ENG-SF22036-R1-Util-CDs.pdf Markup Summary

Subject: Callout
Page Index: 1
Date: 1/23/2023 5:14:51 PM
Author: CDurham
Color: ■
Layer:
Space:
Page Label: [1] 1 118323-TITLE-01 - Layout1

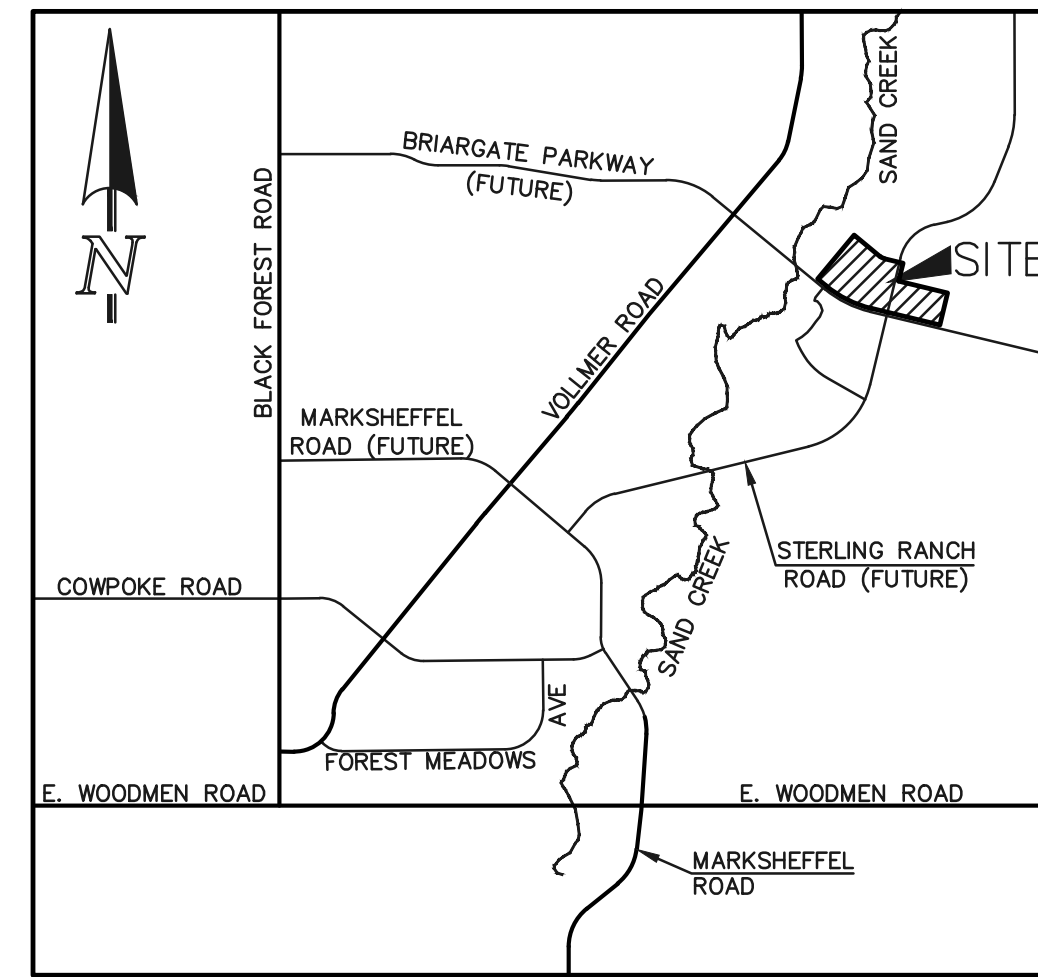
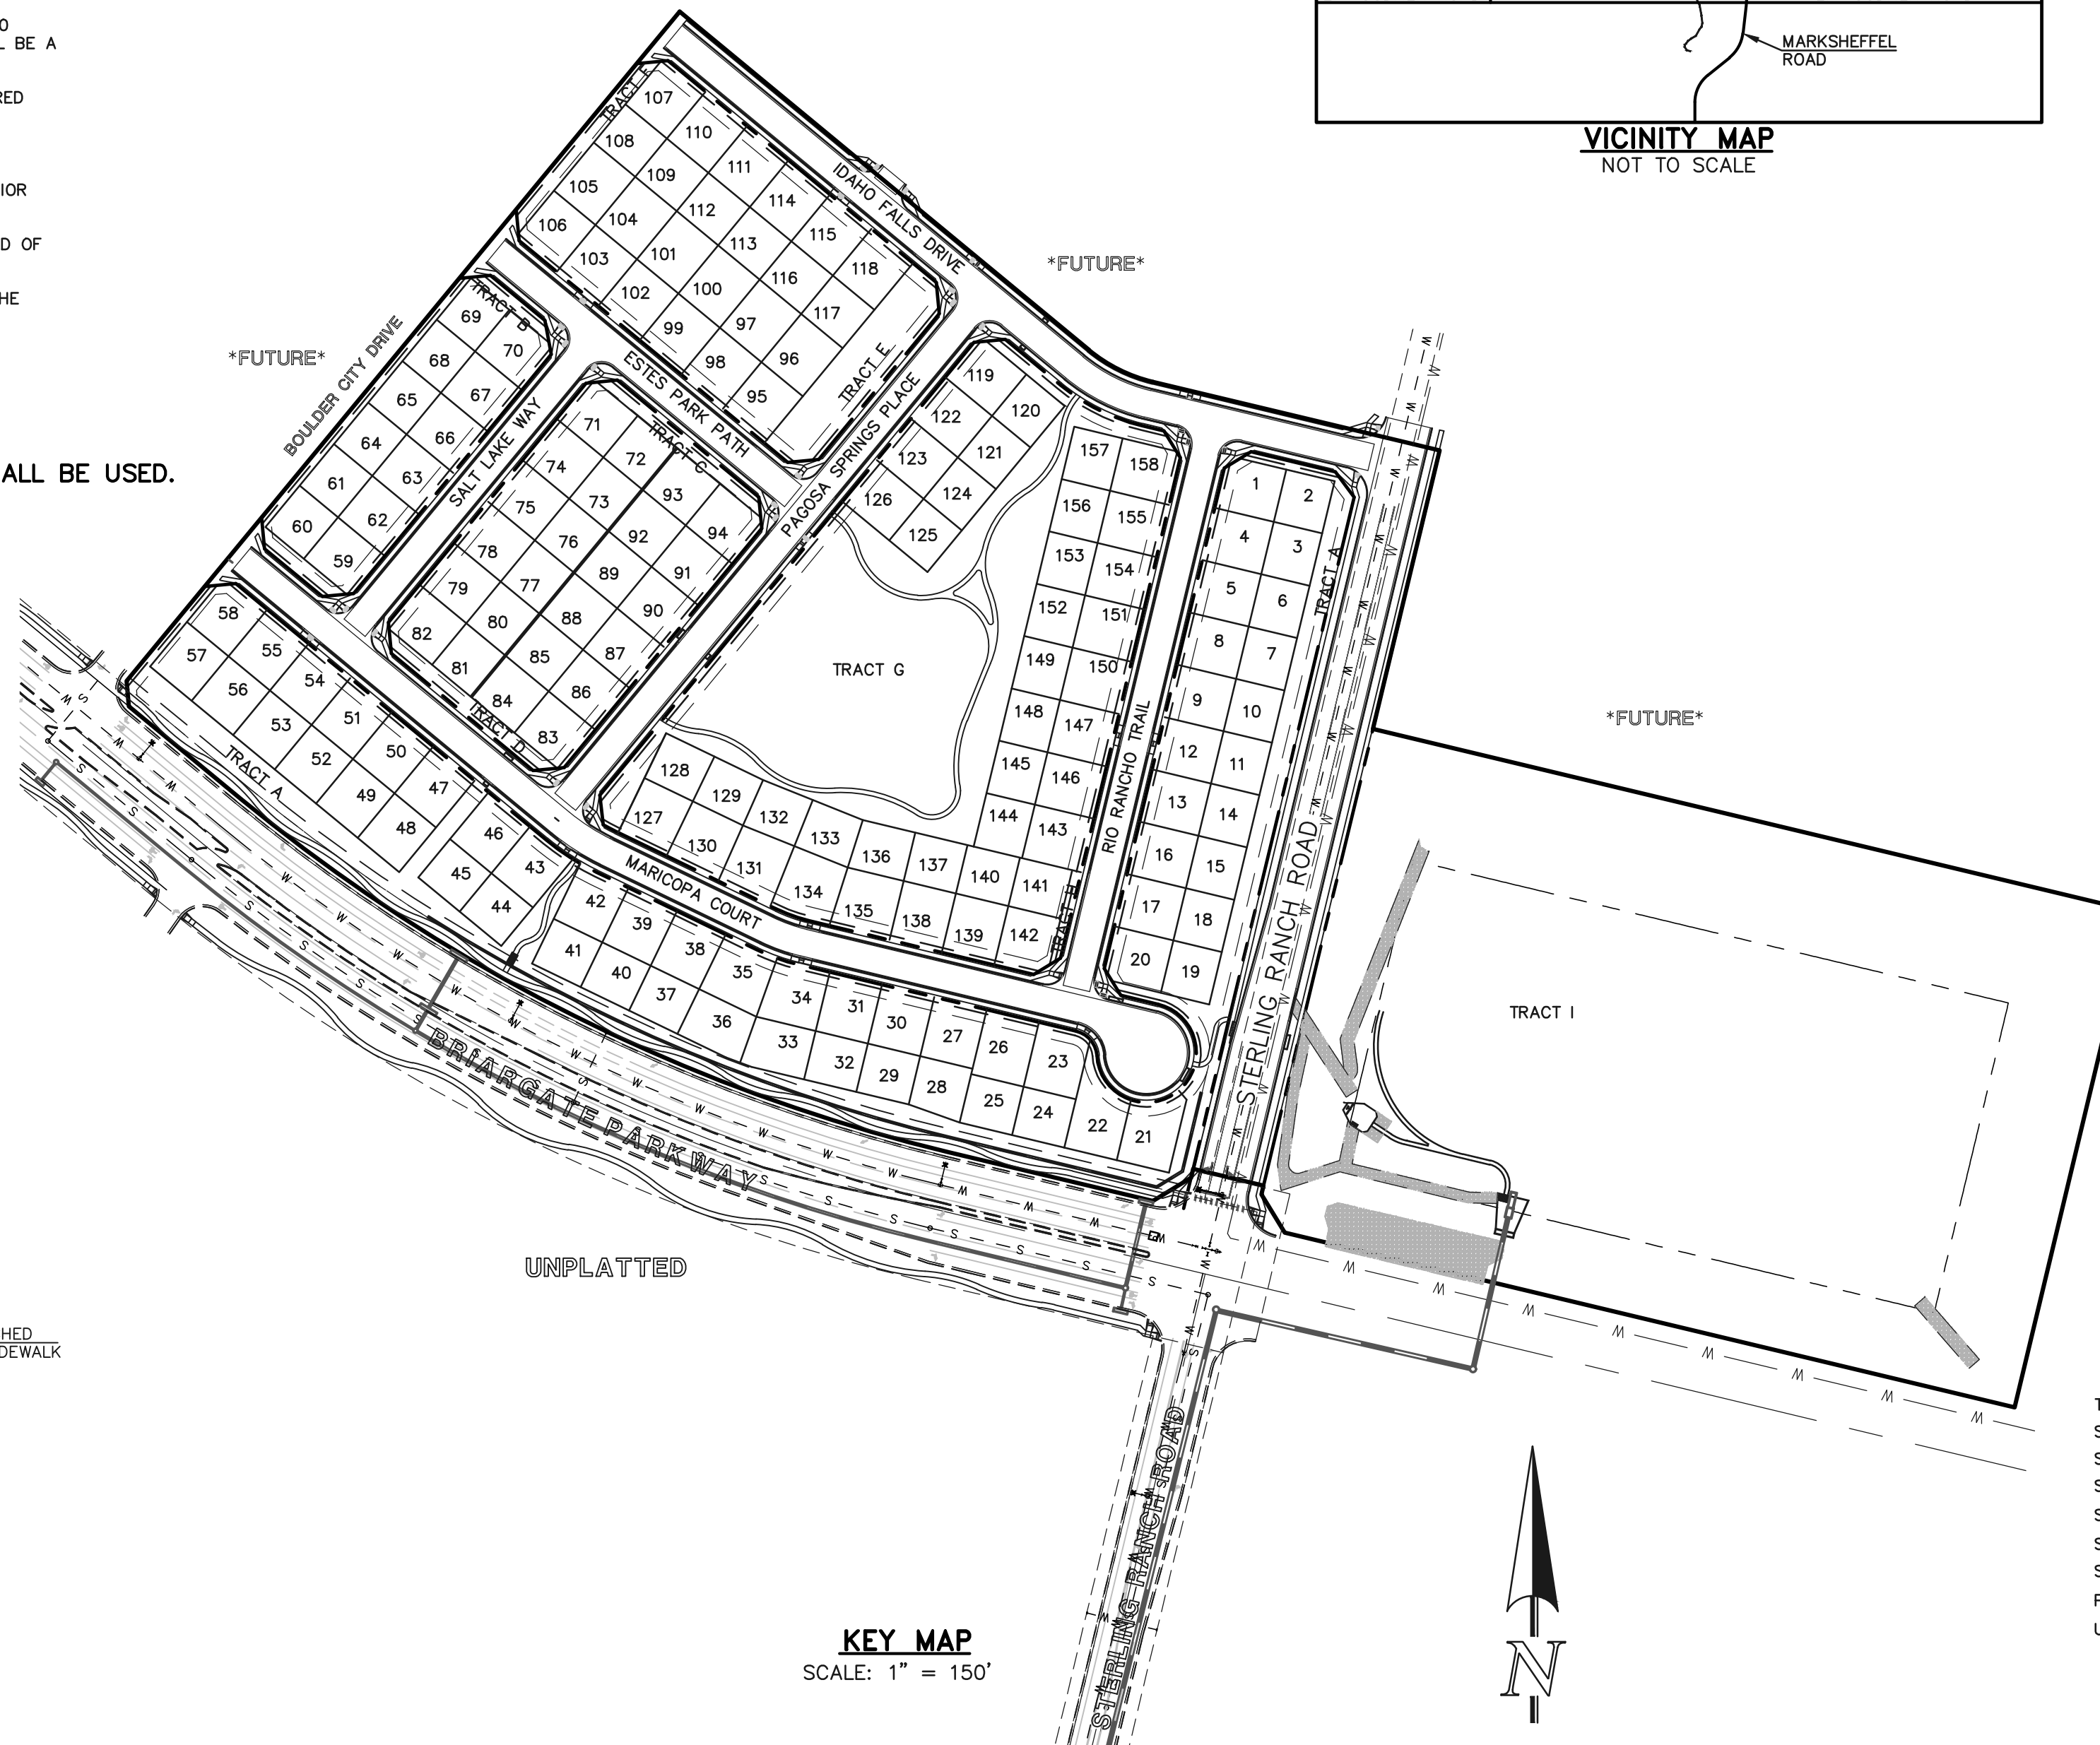
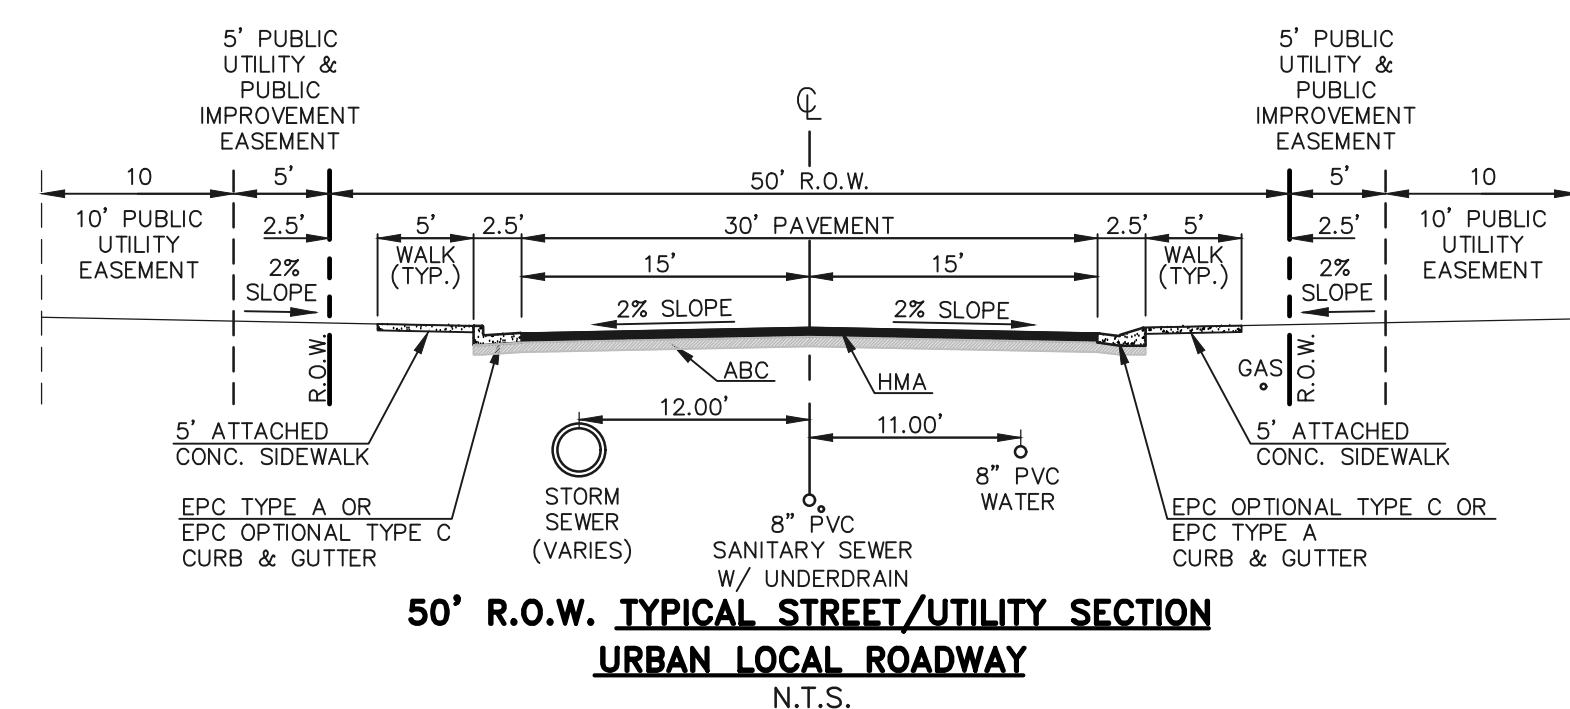
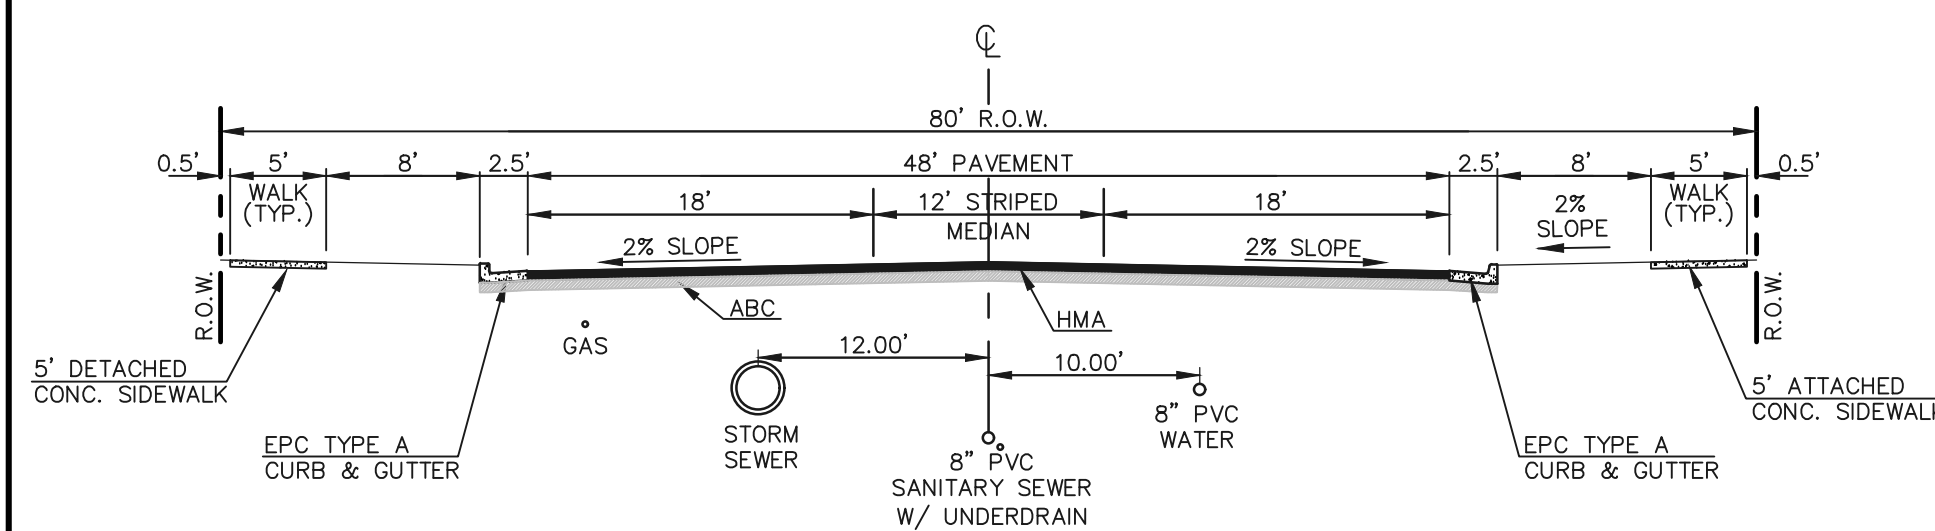
Add information for Basis of Bearings & Benchmarks

2-15' lanes & 1-12' median do not equal 48' pavement width

Plat states this is a 10' utility easement. Coordinate between documents if this is utility or utility & drainage easement and update sheets accordingly.

Update Tract labels to match with Final Plat

Show underdrains

| DRAWN BY | JRH | (H) 1" = 50' | SHEET | 2 OF 11 |

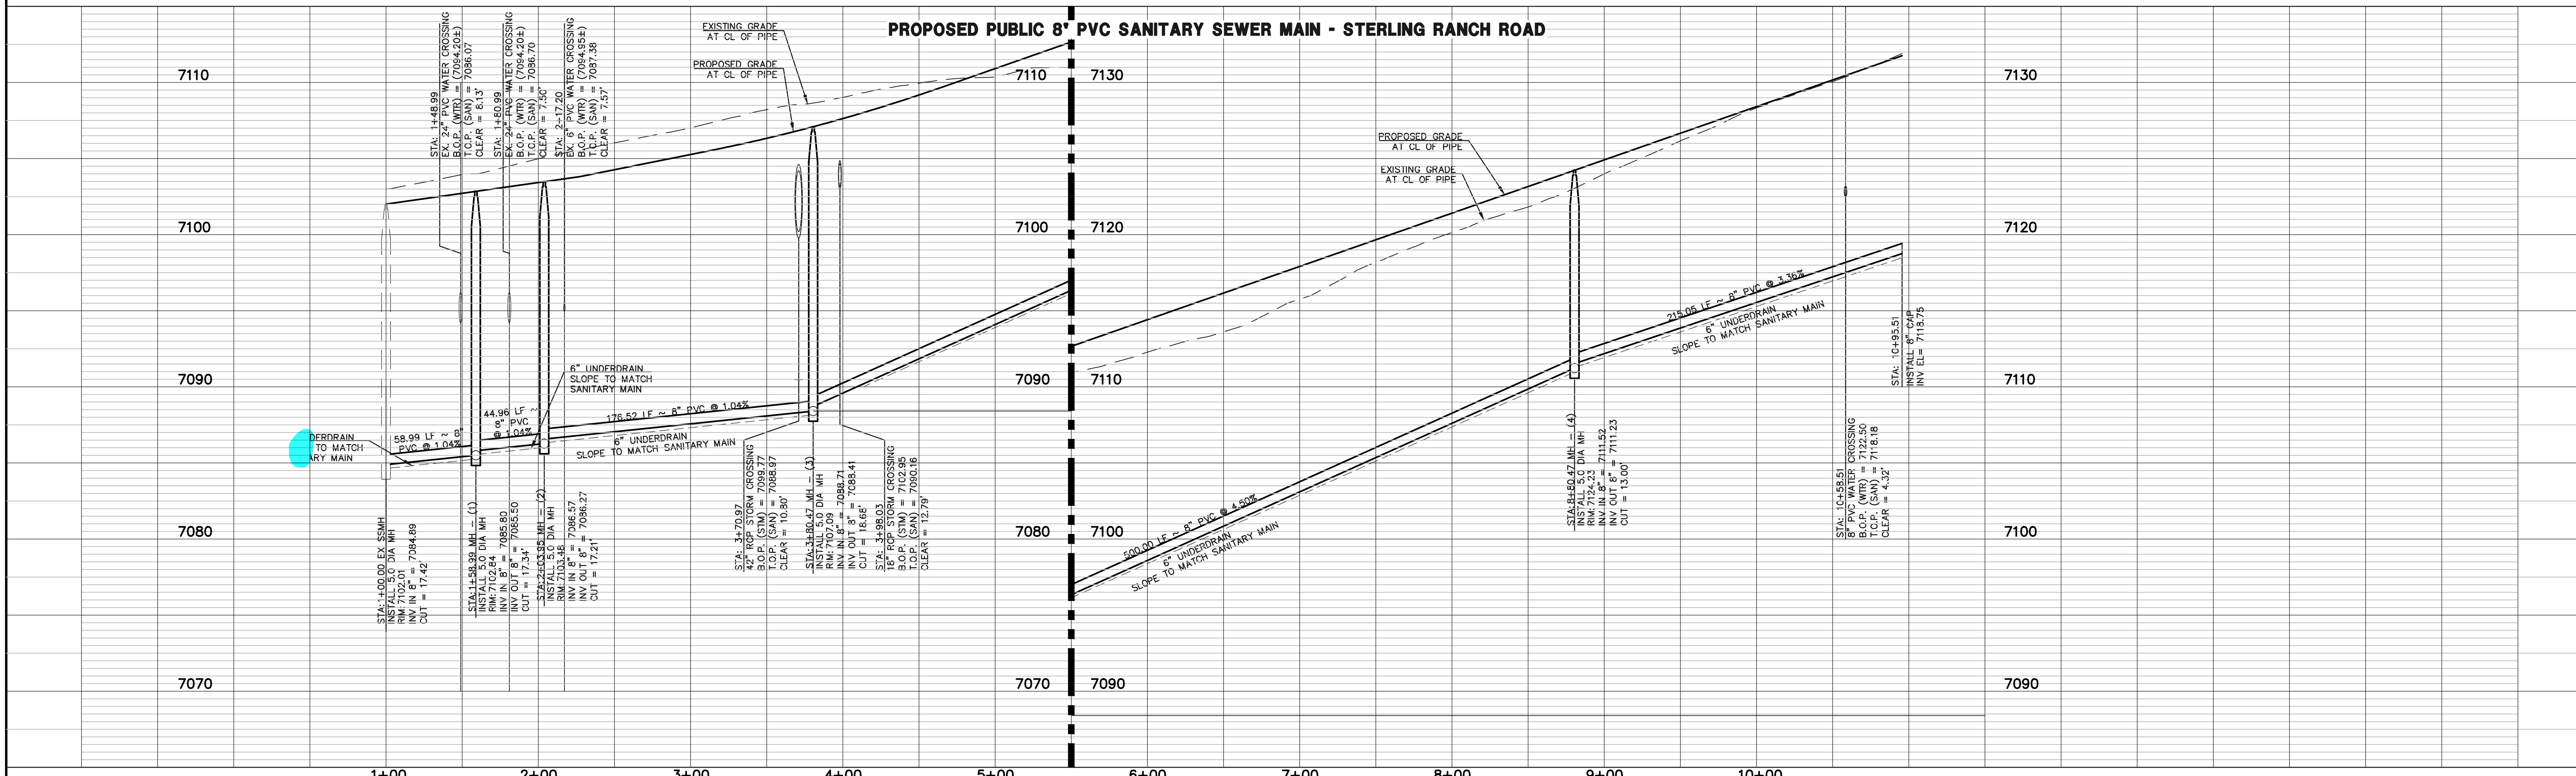
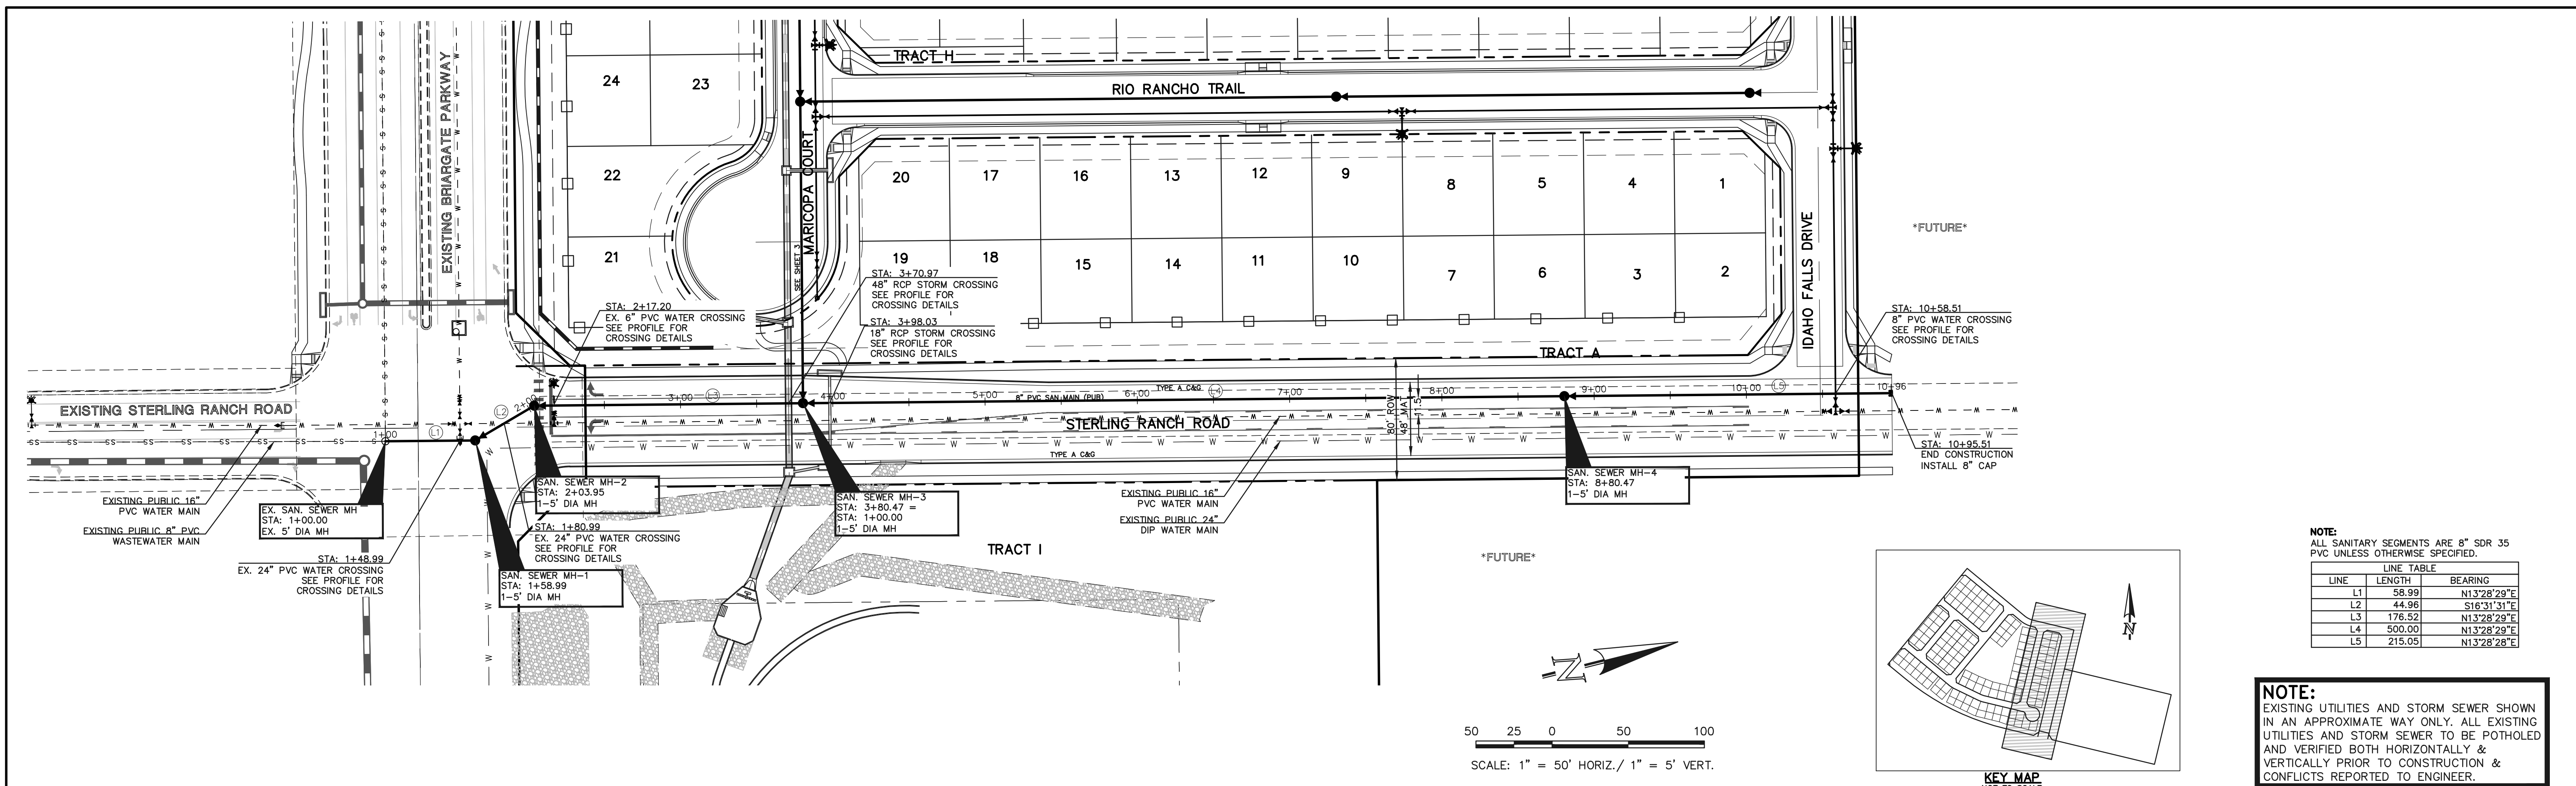
Plan does not show a storm crossing at this location. Remove from profile or show and label in plan view.

Update tract labels

Highlighted items do not match between plan and profile (all sheets)

Include Keymap (all sheets)
